Application Correspondence "Notification of Landscape & SW comments"

**Subject:** Planning Consultation on: BN/54/21/DOC

**Description:** Approval of details reserved by condition imposed under ref BN/50/20/PL relating to Condition Nos 5 - mitigation method statement, 6 - archaeology, 7 - piling risk assessment & method statement, 8 - Construction & Environmental Management Plan, 9 - foul drainage, 10 - surface water drainage, 11 - maintenance & management of surface water drainage, 13 - pre-commencement site meeting, 15 - odour assessment or evidence that livery has ceased, 16 - soil resource plan, 17 - landscaping, 18 - screen walls & fences, 19 - elevation details of 2 proposed communal bin stores and 20 - colour schedule of materials & finishes.

**Location:** Land Rear Of 1 Northfields Cottages Fontwell Avenue Eastergate PO20 3RX

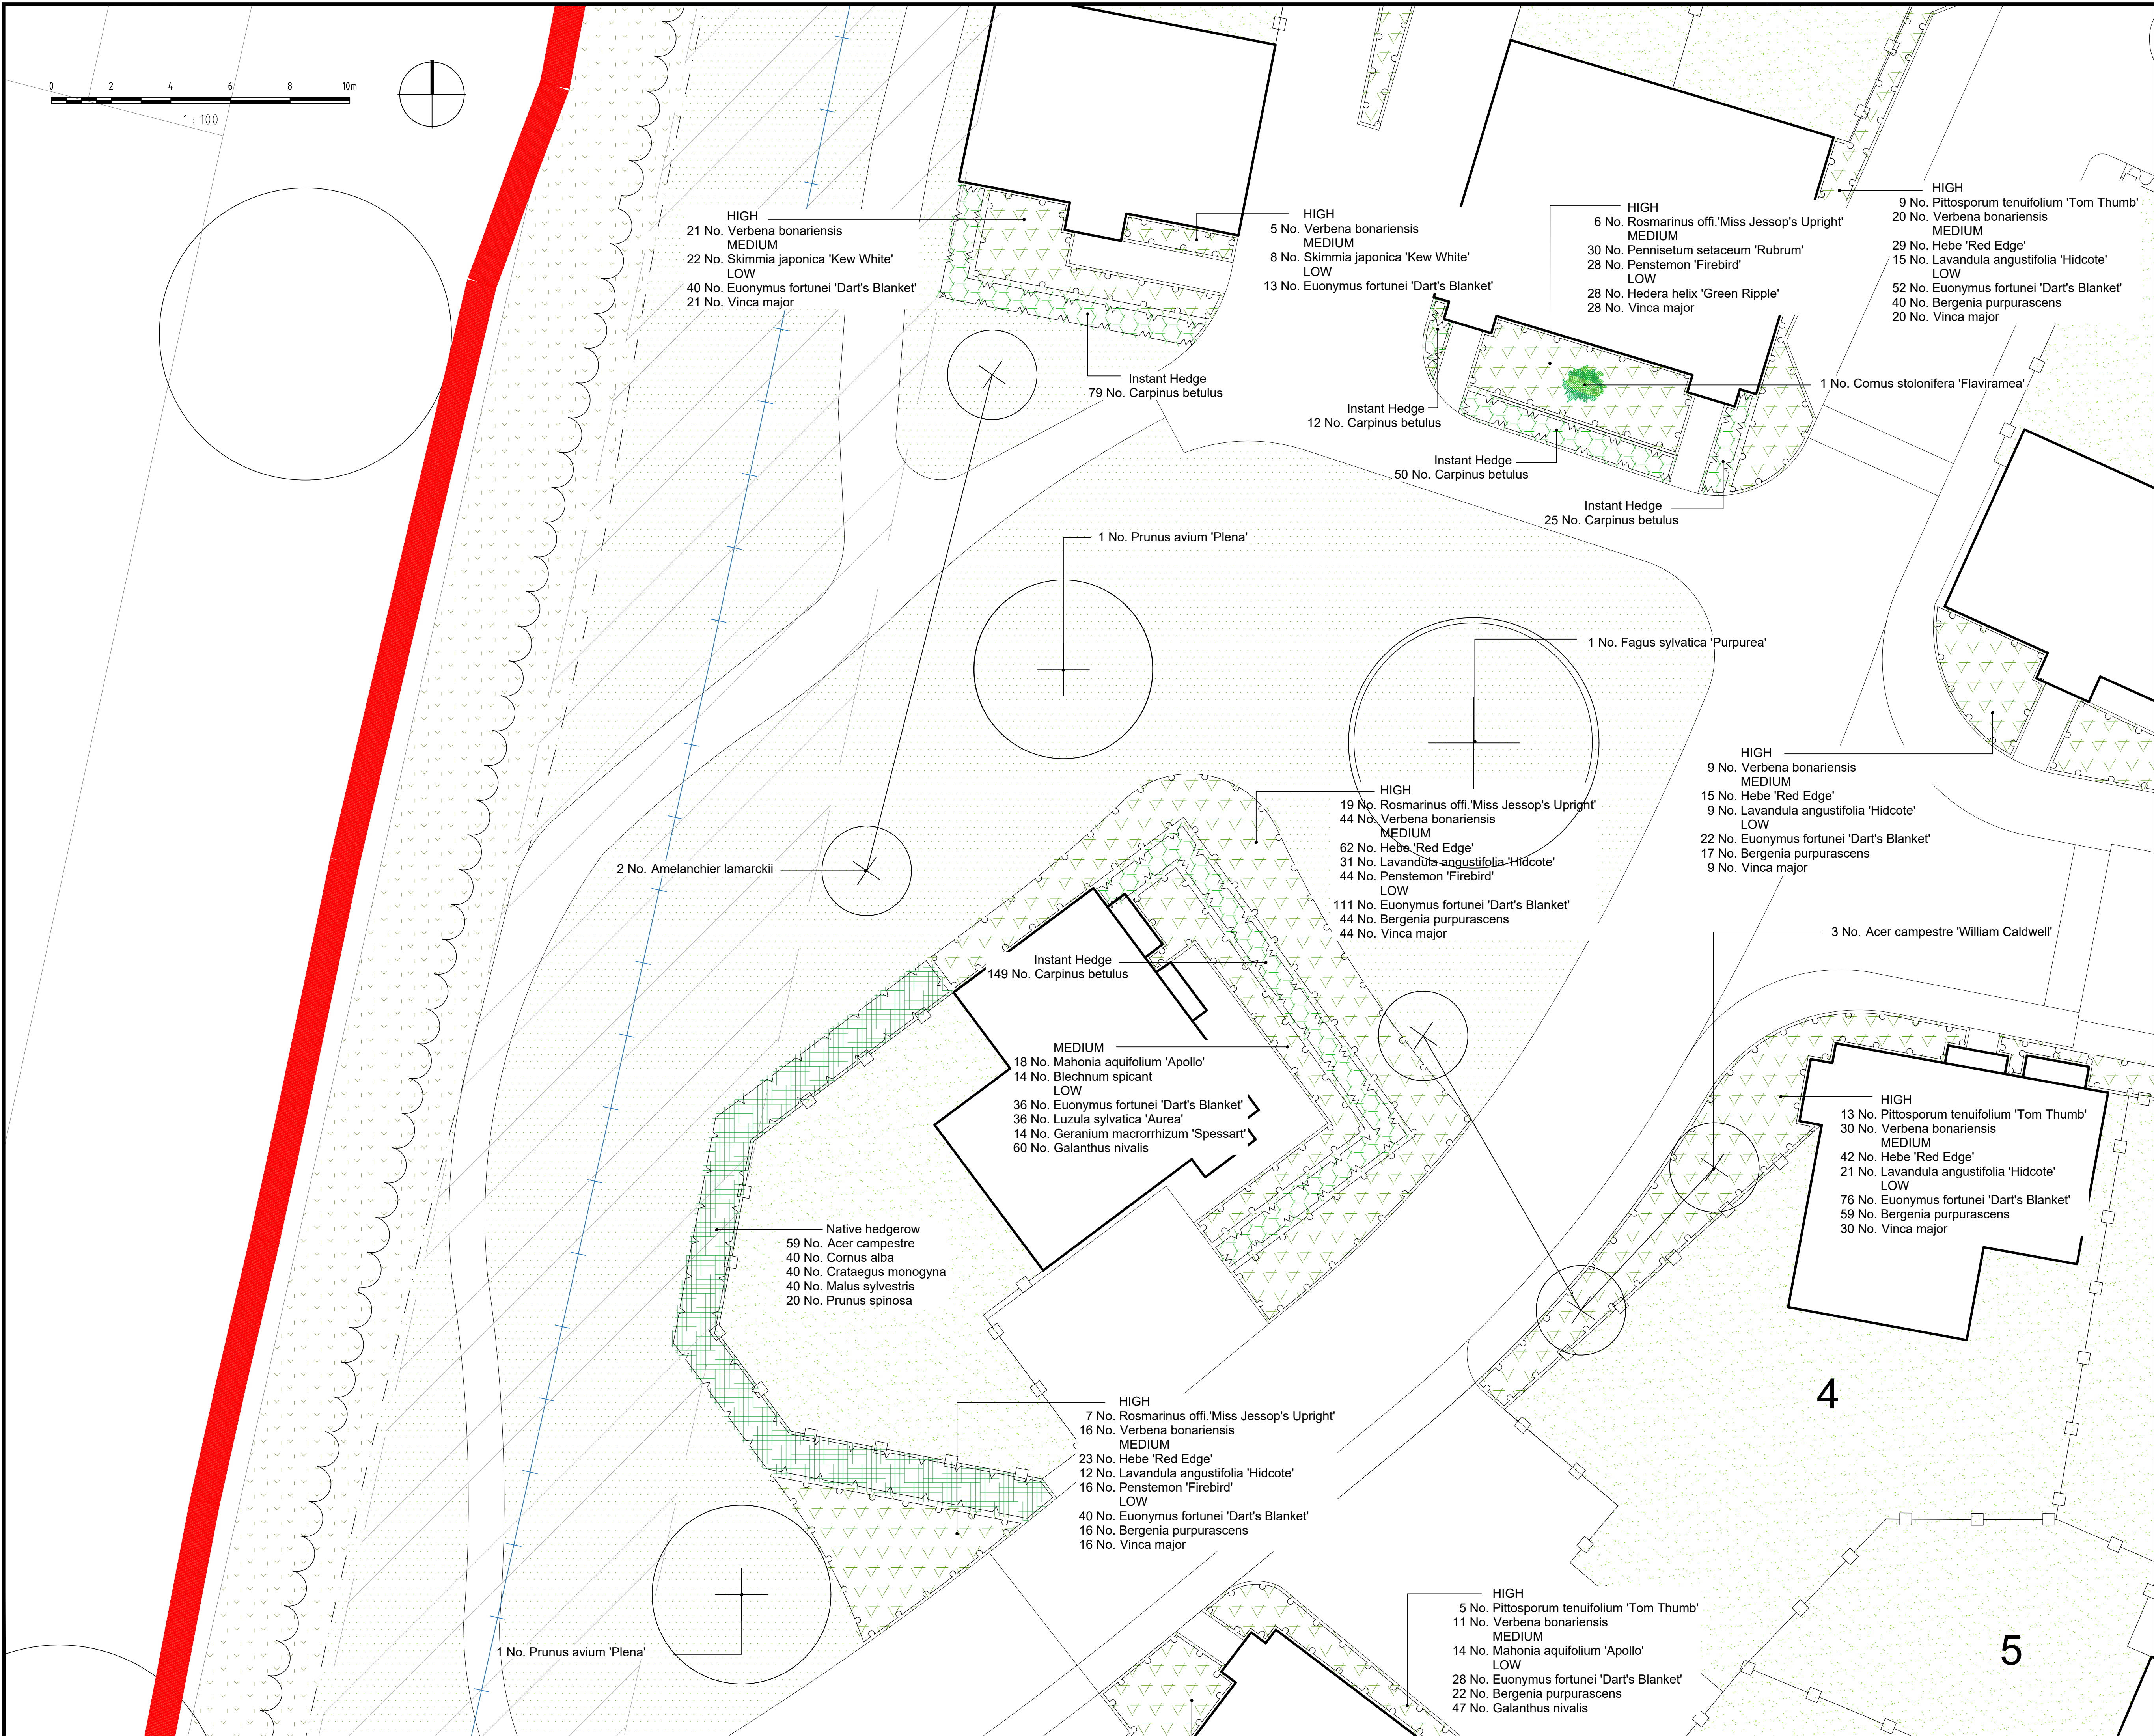
The proposed landscape detail specified in Detailed Planting Plans 1-8 L01- L08 and Coloured Masterplan dwg D2776-FAB-00-XX-DR-L-1000 Rev PL02 have proposed a scheme which would be fitting for location and contains detail including species choice, quantities being proposed, planting densities and size at time of planting.

There would not appear to be any drawings showing which detail the previously agreed play provision of timber fitness items into the POS areas to the n/west area of the site. The Coloured Masterplan dwg D2776-FAB-00-XX-DR-L-1000 Rev PL02 needs to reflect these items and location of these.

**Summary recommendation: Recommend the discharge of Condition 17** Landscaping scheme on this application BN/54/21/DOC imposed under BN/50/19/PL, **subject to** the submission of additional drawing which shows the previously agreed play provision of timber fitness items into the POS areas to the n/west area of the site.
